Lucy Taylor
Kirklees Metropolitan Borough Council
Development Management

Our ref: RA/2024/147181/02-L01
Your ref: 2024/91002

FORMATION OF 2 OUTDOOR COVERED PADEL TENNIS COURTS WITH 9M HIGH POLYCARBONATE CANOPY, ONE UNCOVERED PADEL TENNIS COURT, RELOCATION OF MODULAR BUILDING AND EXISTING OUTDOOR TENNIS COURT AND ASSOCIATED CAR PARKING IMPROVEMENTS, THONGSBRIDGE TENNIS & FITNESS CLUB, MIRY LANE, THONGSBRIDGE, HOLMFIRTH, HD9 7RY

Project No.	Scale	Drawing No.	Revision
LAD_563		PPF-01	REV_1

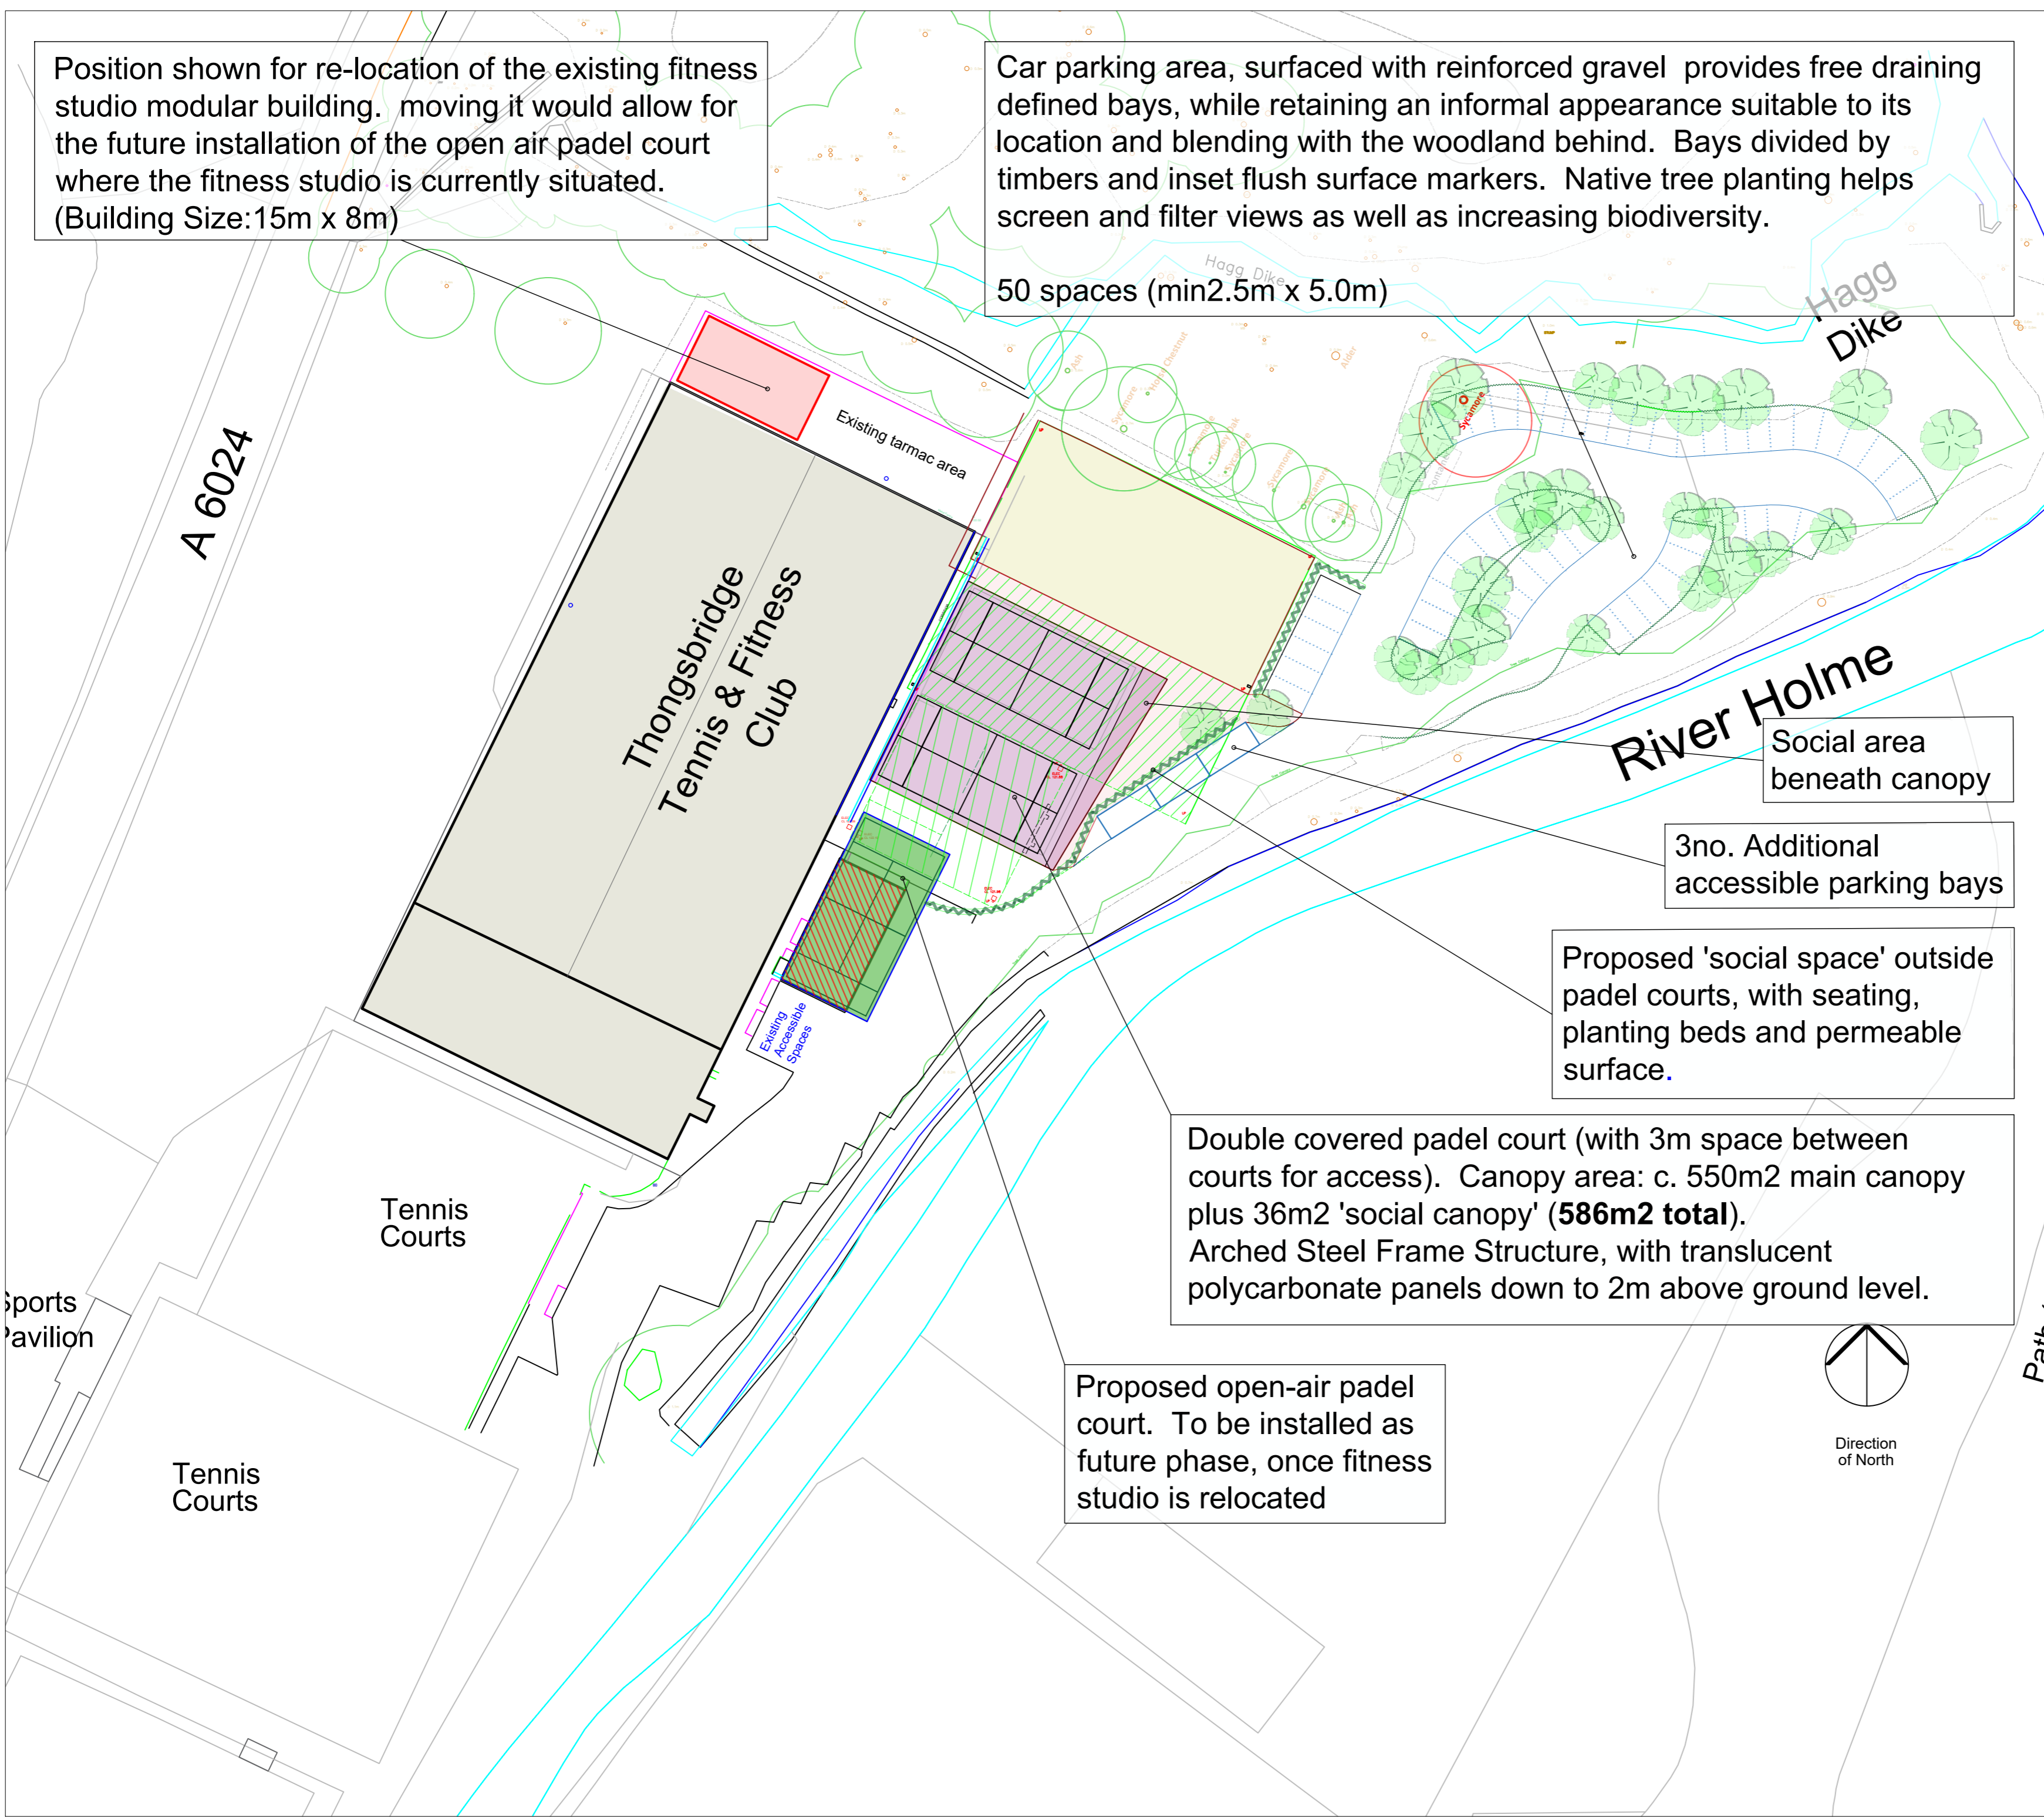
The revised car park drawing (LAD_563 / PPF-02 / Rev1) submitted states:

‘As the revised layout stays within already surfaced areas it does not impact any priority habitat, linear habitat (such as hedgerows) and is below the BNG threshold of 25m² of any on-site habitat. On this basis, no BNG calculations are submitted as part of the application.’

As stated in our previous response, the de minimis exemption, referenced here, as set out in the legislation, applies to development that does not impact a priority habitat and impacts less than 25 square metres (eg 5m x 5m) of non-priority onsite habitat or 5m for non-priority onsite linear habitats. Equally, if a development impacts less than 25 square meters of non-priority habitat but 5m or more of non-priority linear habitat is negatively impacted, or vice-versa, then the exemption will not apply, and all habitats will be subject to full BNG assessment.

We consider that the revised plan does not suitably demonstrate the exemption would apply with regards to the watercourse habitats. The plan is not very clear and appears to show tarmacked surfacing, parking spaces and tree planting encroaching on the two watercourses (within 10m from bank top) and along a length of greater than 5m.

Furthermore, although the applicant mentions linear habitat, they have focused solely on the 25m2 exemption rule with no reference to the 5m rule nor the watercourses (which would fall within this category) therefore it is unclear if the 5m rule would also apply or not. As it is being left open to personal interpretation, it is not clear whether the de minimus exemption applies with regards to watercourses and as such we ask that the LPA recommend that the applicant submit an improved revised plan that suitably demonstrates where the watercourses are, and where the bank top is with lengths and distances shown.
